Submission No.			192	
Organisation Name or Name of Submitter			Michael McDowell	
Item No.	Section Ref.	Page No.	Observation Statement	TII Response
2023 Metrolink Railway Order Planning Observation - Senator Michael McDowell, Leinster House, Dublin 2 - 16 th of January 2022				
1	Introduction	1	Metrolink risks damaging a lot of Dublin’s transport resources. This submission focuses primarily on the problems of locating the terminus in Charlemont for both residents and commuters. As an advocate for preserving historical structures, I am particularly concerned about how many buildings will be destroyed due to Metrolink’s construction.	<p>Thank you for taking the time to make a submission. TII have reviewed your submission and responded to the observations made below.</p> <p>TII do not agree that "Metrolink risks damaging a lot of Dublin’s transport resources" and in fact does the opposite. EIAR Chapter 3, Background to the MetroLink Project, explains how the proposed Project will provide significant benefits not only to those who choose to use it, but also to other transport network users, by generating a modal shift from private car use, thereby reducing the demand for road space and

Client	TII NTA	Project	METROLINK	Drawing Title	METROLINK - STRUCTURES CHARLEMONT STATION PROPOSED STREET LEVEL DESIGN	Drawing Status	S0
Consultant	JACOBS IDOM	Drawing N°	ML1-JAI-SRD-ROUT_XX-DR-Z-02090	Plan Drawing N°	ML-ST 307 O-A1		
		Scales Original Size A1	1:250			Sheet	1 of 6

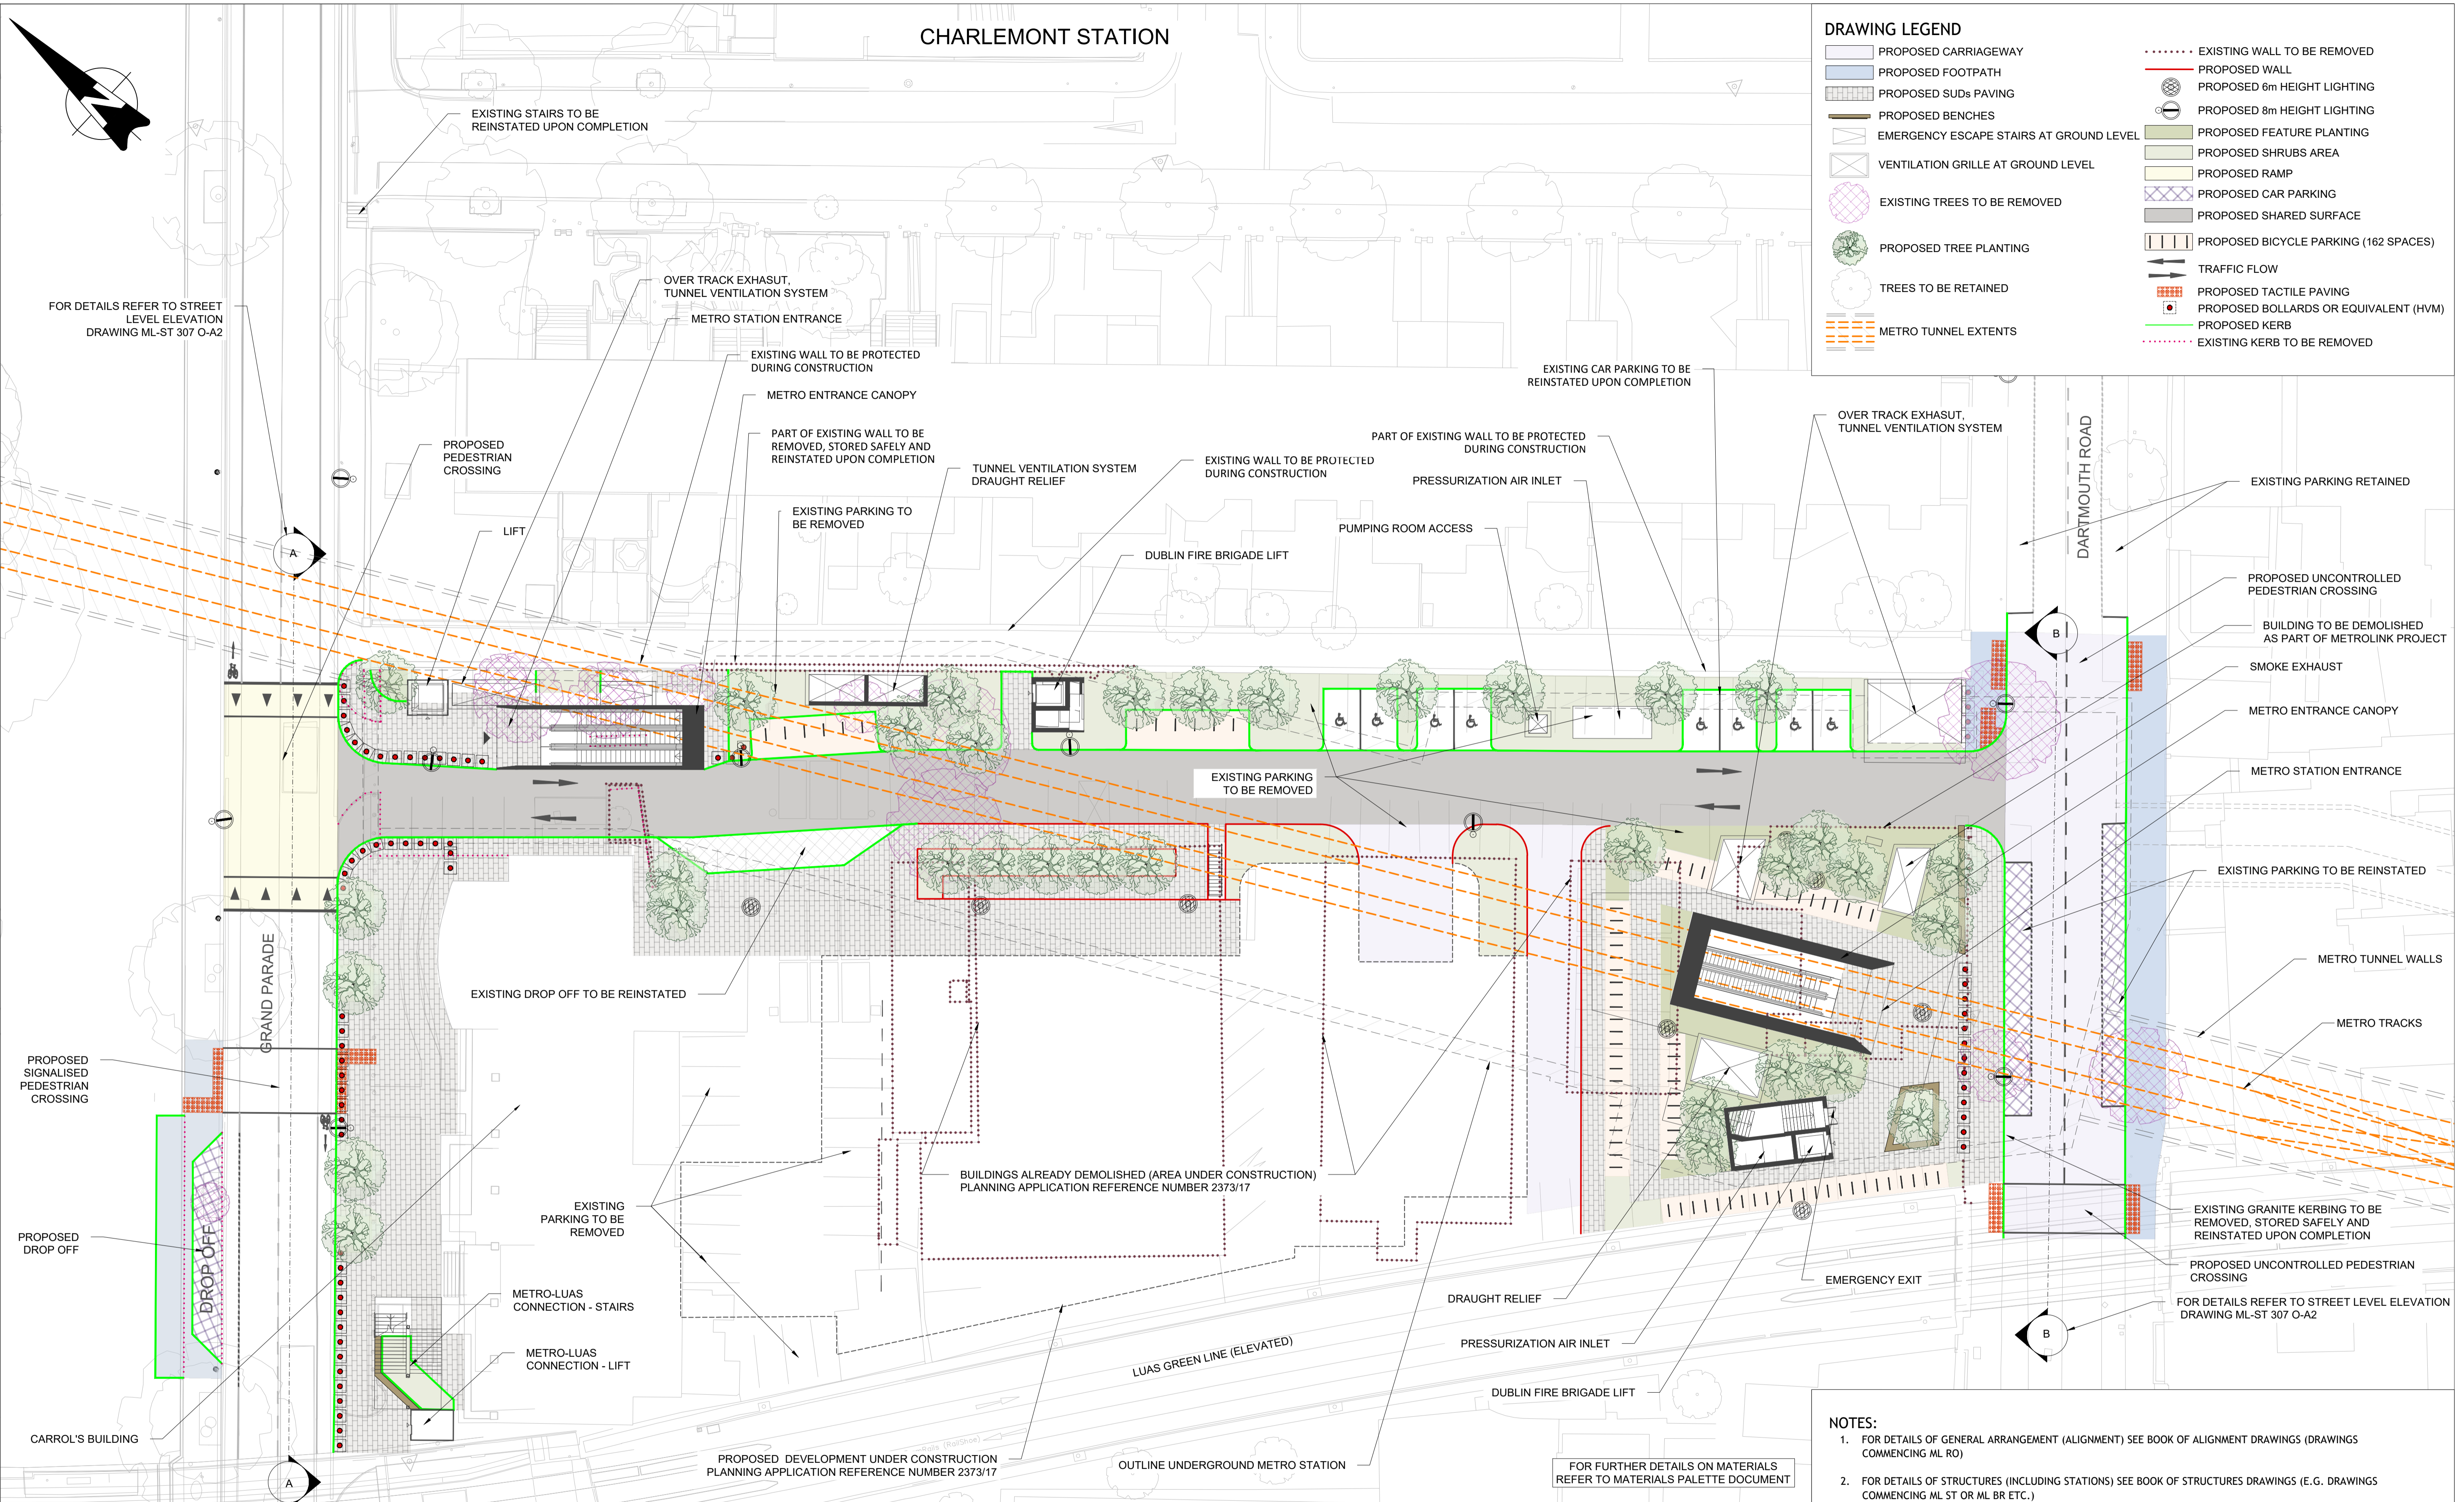
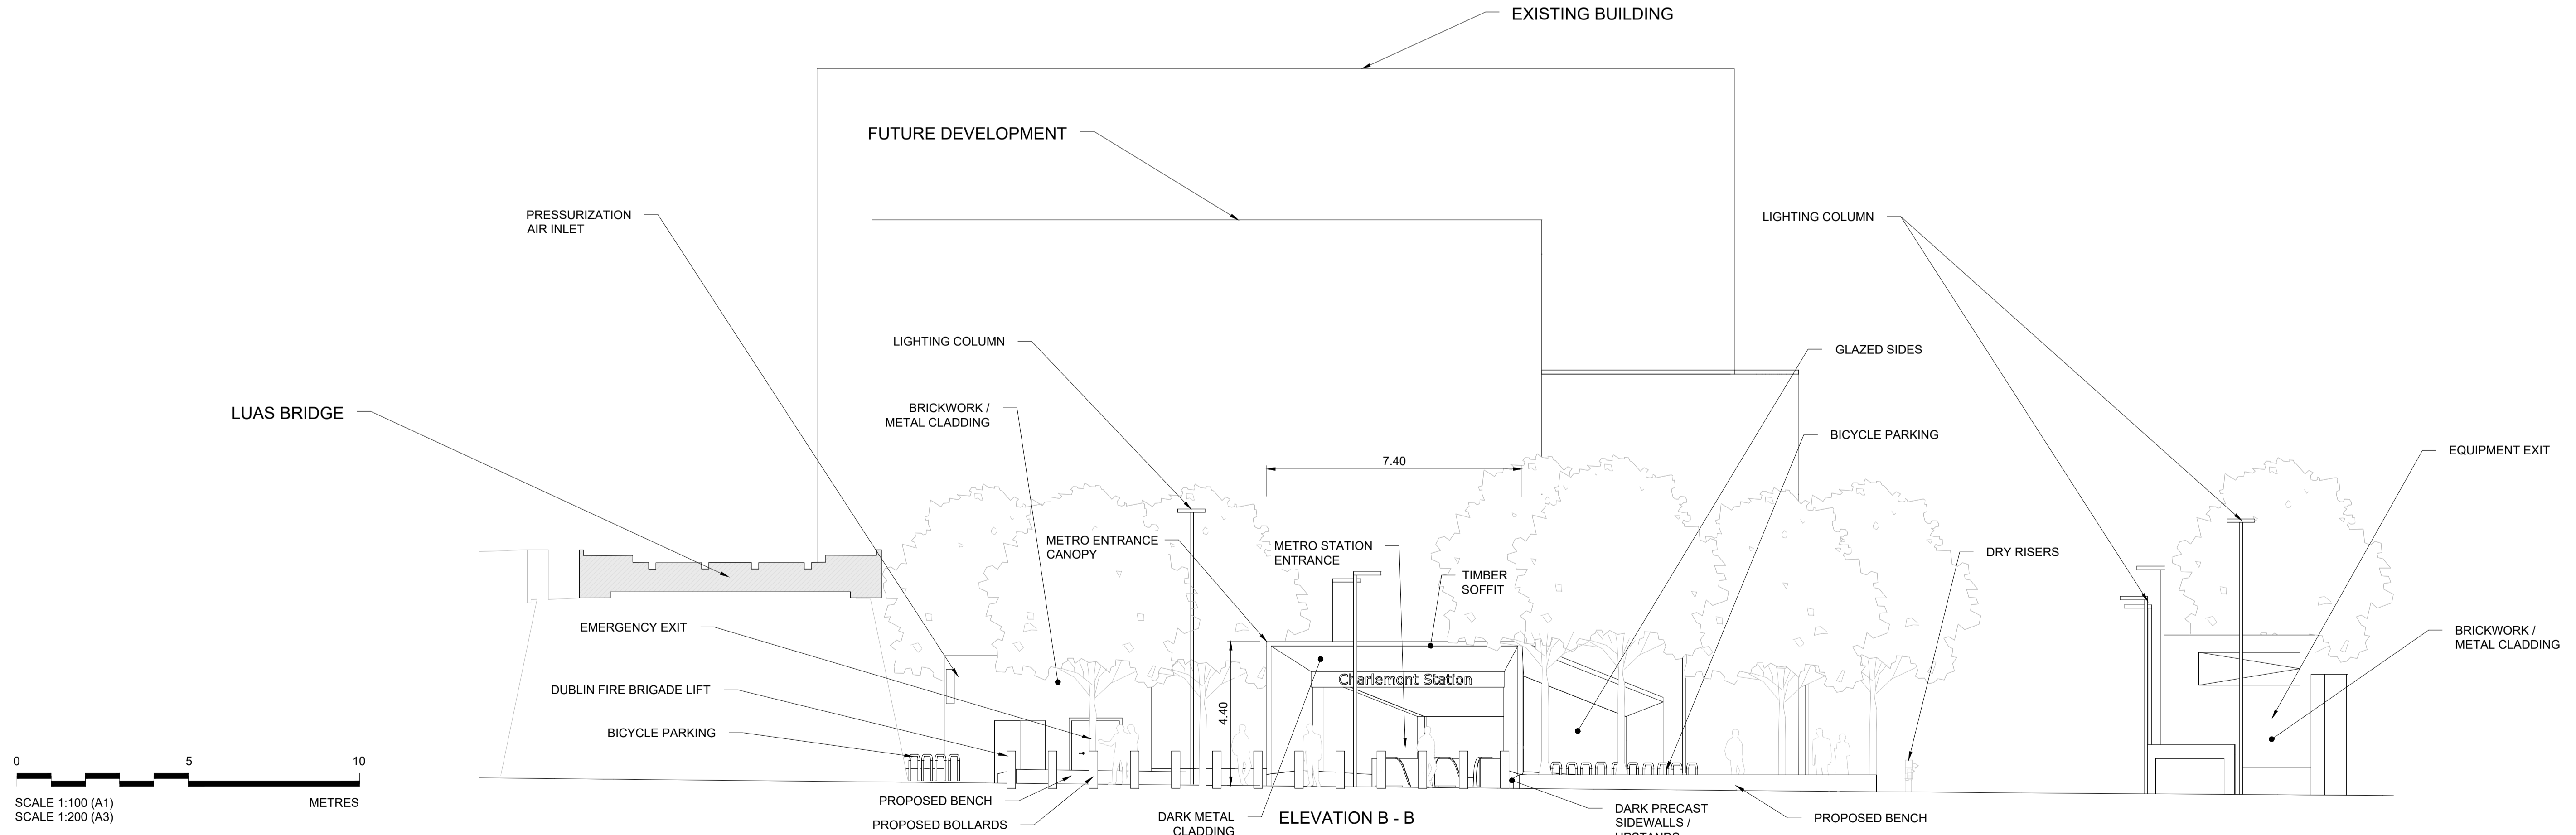
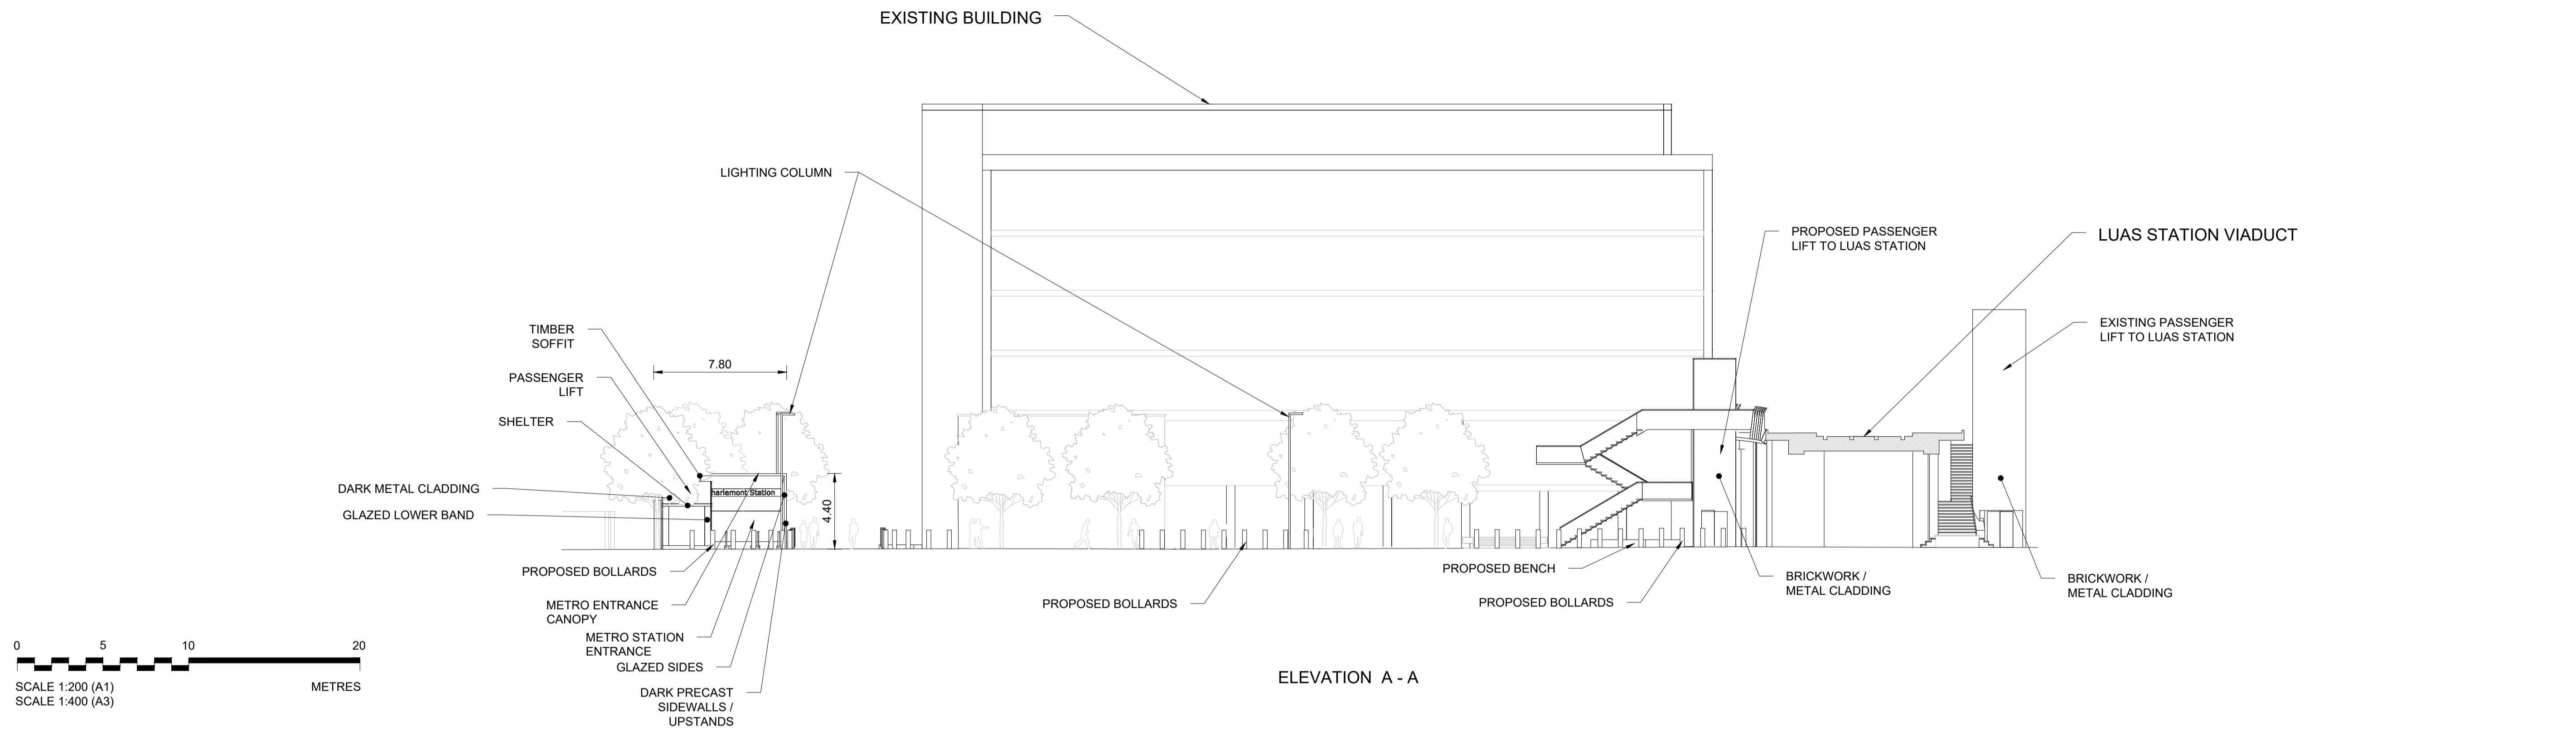
2	Problems for Commuters and Local Residents Near Metrolink Stations	1	The roads in the Charlemont area are very narrow. If drivers want to drop off or collect commuters from the terminus, it will cause congestion and other traffic-related issues.	<p>TII have undertaken detailed transport modelling, further details below, that shows MetroLink will not cause congestion and related traffic issues. TII have deliberately designed the Station with minimum set down space (with the exception of a drop-off on Grand Parade for persons of restricted mobility only) or room for taxi ranks so that it does not encourage the Station to be used as a terminus, and instead as intended, as a through transport corridor.</p> <p>The MetroLink is designed to form part of an integrated public transport network with Charlemont selected as the preferred interchange location in order to maximise the potential interchange with the existing Luas Green Line. In overall terms, Charlemont Station will provide for improvements to the public transport network resulting in decreases in private car usage/trips, increases in public transport usages and will facilitate walking and cycling to the station, without significantly impacting on the operation of the road network in the area.</p> <p>A microsimulation VisWalk model has been developed for the immediate area surrounding Charlemont Station during the operational phase. The model covers the full extent of the publicly accessible station area, including the immediate vicinity of the station entrance at street level, the Luas stop and nearby junctions at Charlemont Bridge. In order to accommodate the forecast demand from the proposed Charlemont Station, a new staircase with 2.4m stair width is proposed at the south east corner of Charlemont Luas stop. An elevator will also be provided at this location. Both are sized for MetroLink to Luas, and Luas to MetroLink passenger numbers.</p>

Response (2) continued.	<p>In addition, it is proposed that the pedestrian crossing on R111 Grand Parade will be repositioned to the front of the building being developed by Hines. With this infrastructure in place, the model indicates that the R111 Grand Parade will have an acceptable level of service overall, with some reductions in service seen at the pedestrian crossing where pedestrians are required to wait for a green phase at the signals. Overall, it is considered that the model displays an acceptable level of network performance.</p> <p>The proposed pedestrian crossing on Grand Parade will have minimal impact on the traffic flow along Grand Parade and can be programmed to operate in sync with the existing signalised junction at Grand Parade /Charlemont Street to maintain the flow of traffic movements. When the Project is operational, car mode share will decrease, with a reduction of up to approximately 830 car tips to and from the zones surrounding Charlemont Station over the 12hr period in 2065. In overall terms, the Charlemont Station will provide for improvements to the public transport network resulting in decreases in private car usage/trips, increases in public transport usages and will facilitate walking and cycling to the station, without significantly impacting on the operation of the road network in the area. The EIAR Chapter 9: Traffic & transport, Appendix A9.2-B Traffic and Transport Assessment Charlemont Station, Section 6.1.2. refers.</p>
